AL/143/24/RES

Outline Conditions

Senior Officer Comments

Title: Play and Open Space Proposals Sheet 1

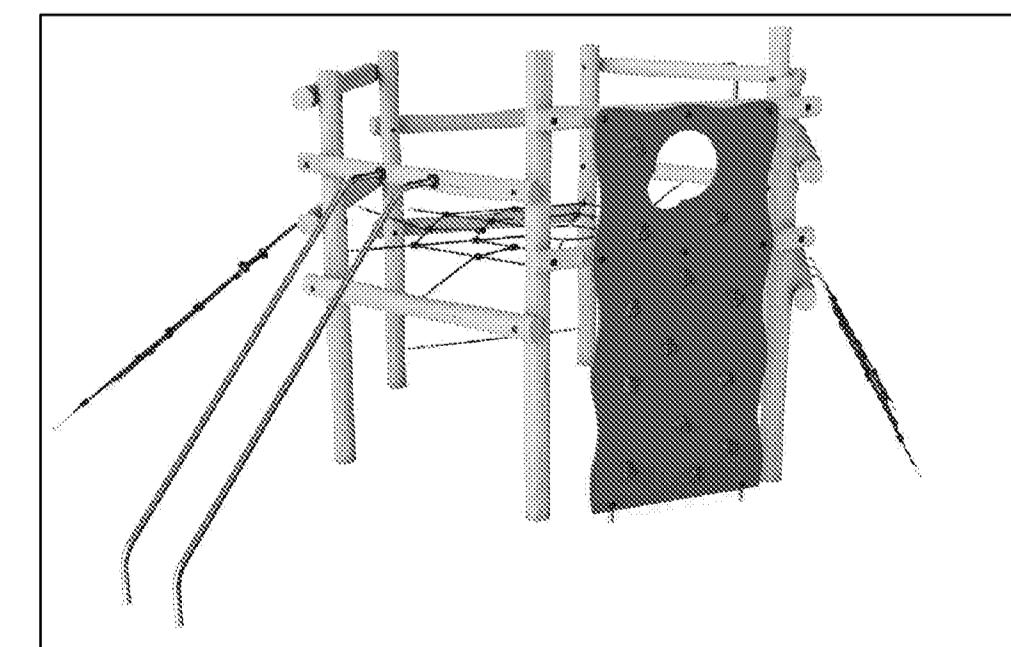
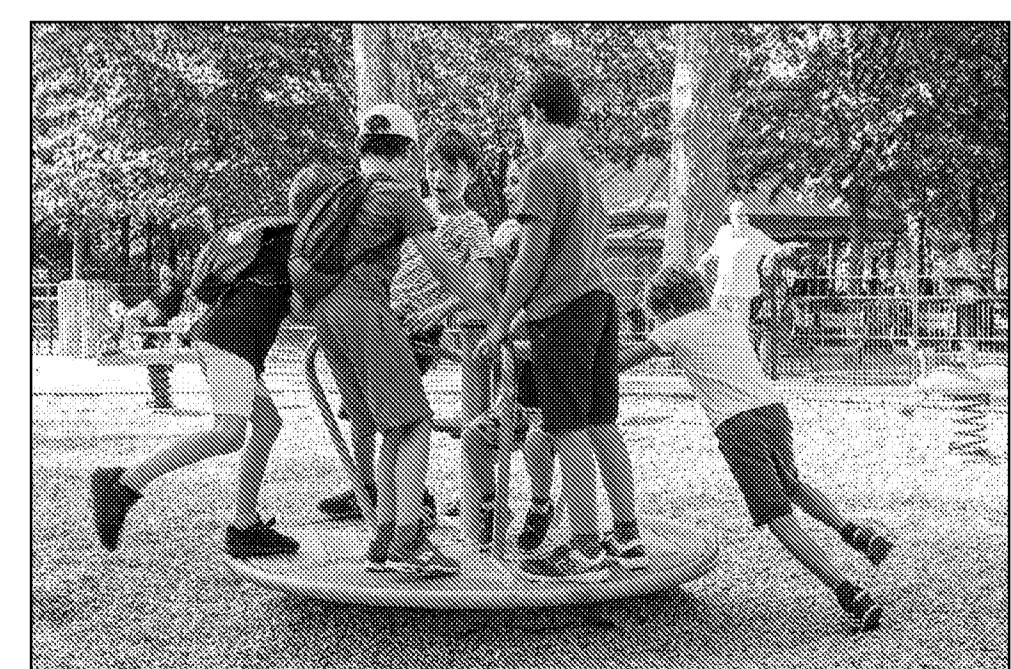
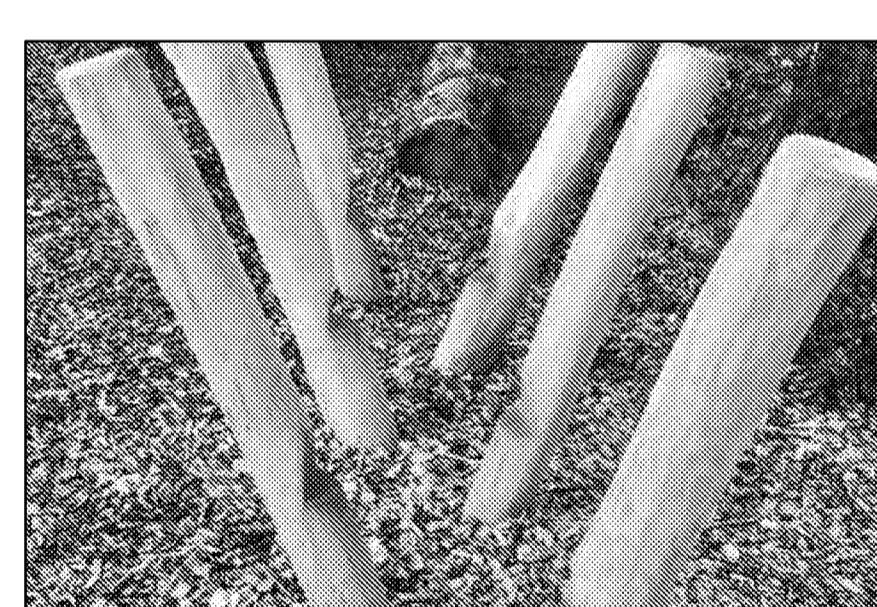
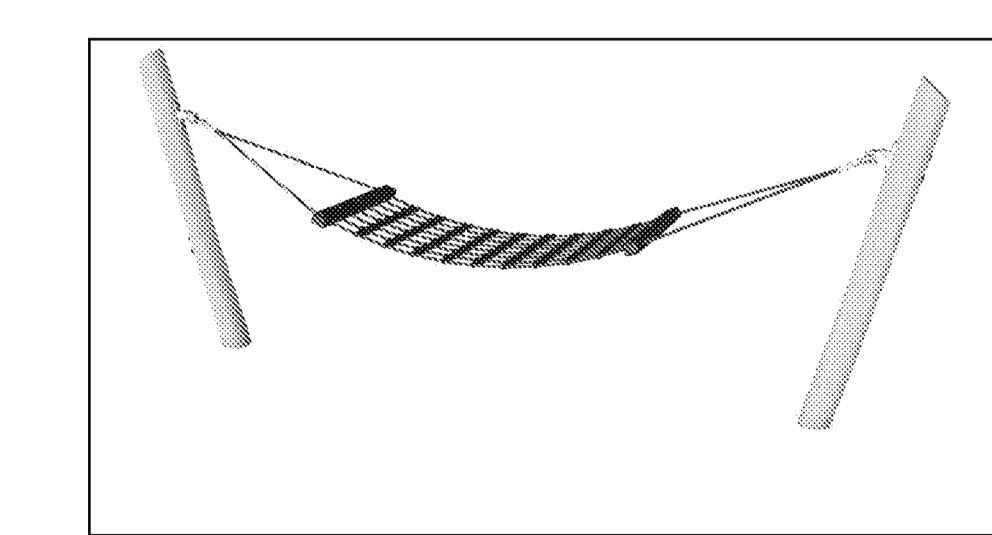
Condition 9 requires that the RM submission includes full details of POS and play provision.	Play Area plans are provided.
Condition 10 requires that the RM submission include details of EVCP, a levels survey, 5% disabled parking, cycle storage details (including elevations), and a colour materials schedule.	<ul style="list-style-type: none"> - EVCP locations not shown (DAS states to each dwelling) and no details of spec (EH have asked for this) Applicant response: An EV charging plan is now provided, showing location of charging points, as required by Building Regs - Levels survey included - (see comment elsewhere) - State in sheds or garages (no plans of sheds – need condition) - Materials Plan indicates base colour of materials. Materials are then shown in colour in the DAS.
Condition 12 requires M4(2) and M4(3)	Planning Layout shows 65 x M4(2) and 2 x M4(3)

Need 7,838m2 of POS and Play provision to include 2 x LAP and LEAP (400m2). Provide LEAP and 2 x LAP (which are all spread out) and state they meet the POS requirements **but no info on proposed amount of open space in m2 (no breakdown of areas to check whether useable)**. Await Landscape comments
No detailed drawings of landscaping yet landscaping applied for (await Landscape comments).
Applicant response: A landscape area calculation is now included, showing that landscape/open space provision meets required standard. Detailed planting plans are being prepared

A	Screen fence Hedgehog Highway added	03.03.25	SW
Boundary Treatment Details			
Project:	Lidsey Road - Phase 1	Woodgate	
Client(s):	BDW Southampton		
Drwg No:	ST-22-14	Rev:	A
Scale:	1:20 @ A1	Date:	10.09.2024
Drawn By:	SW	Checked By:

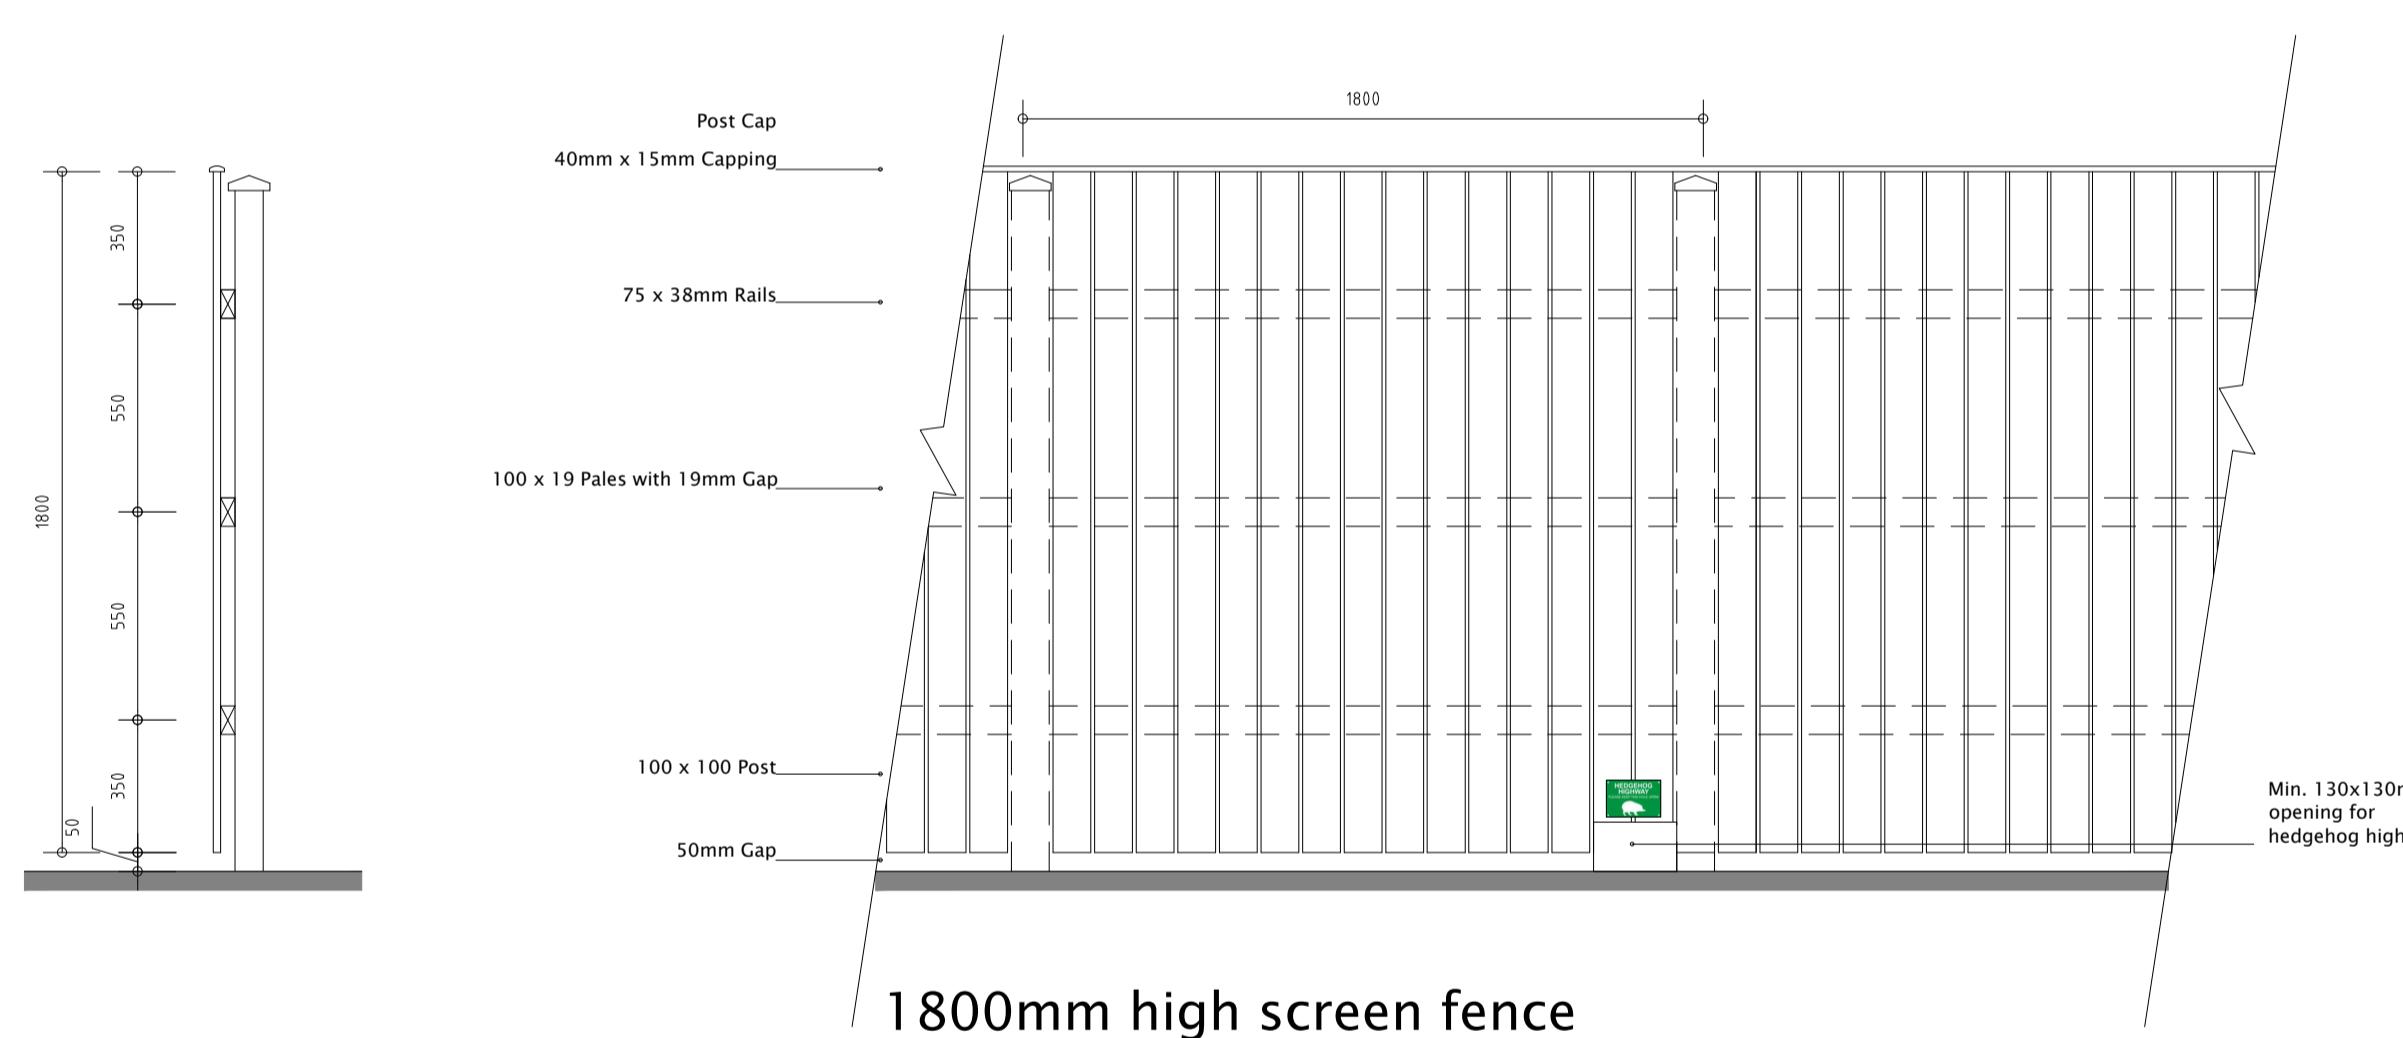
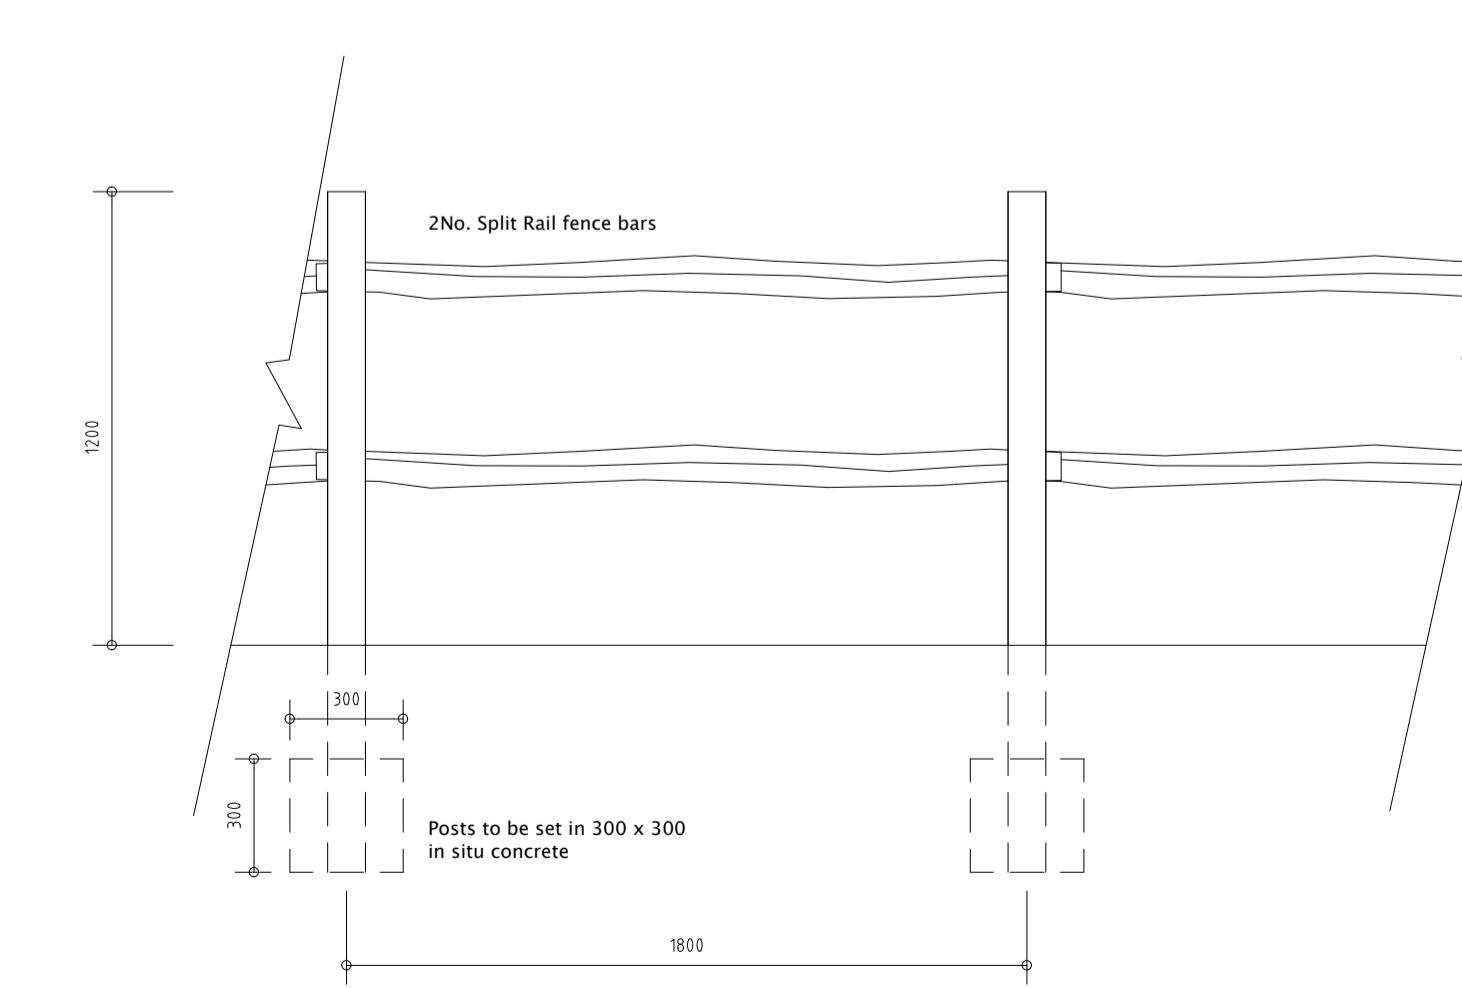
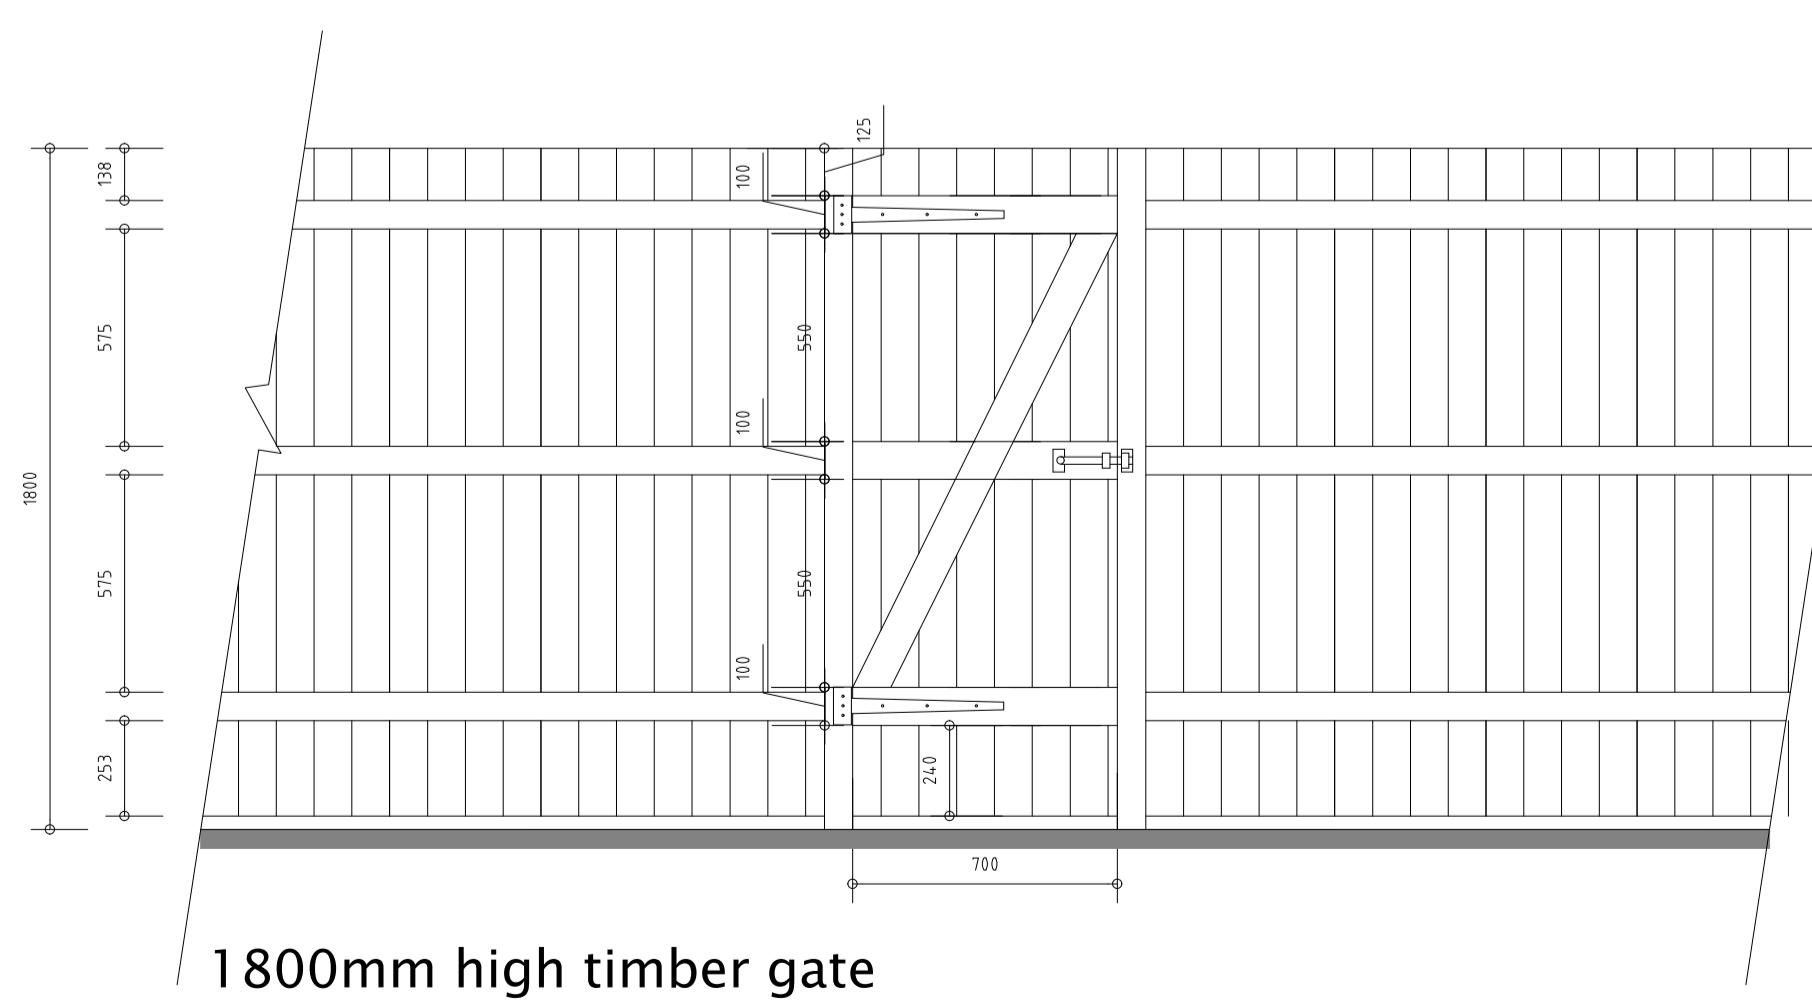
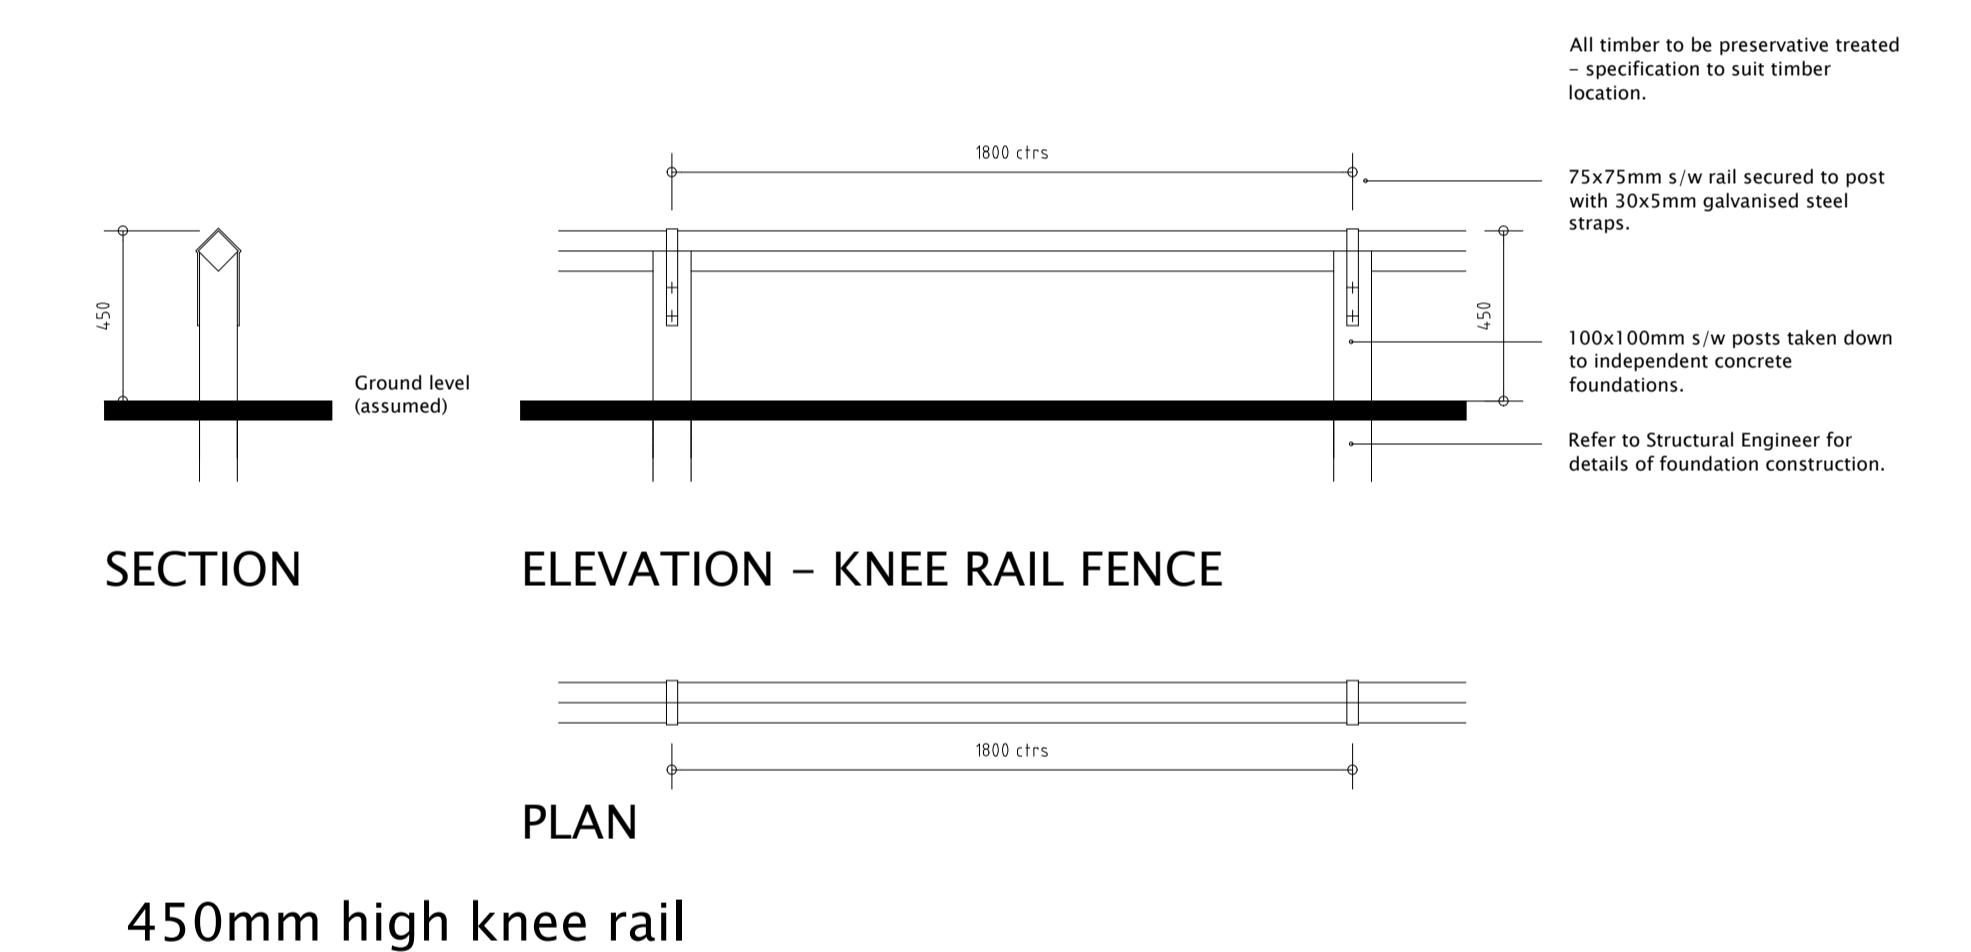
Condition	Compliance
Condition 7 requires 1.8m high acoustic fencing to protect the houses adjacent to the western boundary and also adjacent to the northern boundary of the northern most part of the site. The RM shall include full details of this including design and placement.	Yes, shown on layout plans. EH raise no concerns.
<p>Condition 8 requires:</p> <ul style="list-style-type: none"> - Tree survey documents - Details of boundaries inc hedgehog holes - Mitigation Method Statement ref 5m wide dark buffers on W & S boundaries - Landsc Management Plan - External Lighting proposals 	<ul style="list-style-type: none"> - Yes - Yes but no holes shown (or at least not obvious) and no fence elevations Applicant response: The amended boundary treatment plans now show the inclusion of hedgehog holes - Yes - State is included but not obvious where. - Street Lighting plan provided. No details of any lighting to individual homes – assume none? Applicant response: Street lighting is shown on the lighting plan, sensitive porch lights will be provided to individual plots
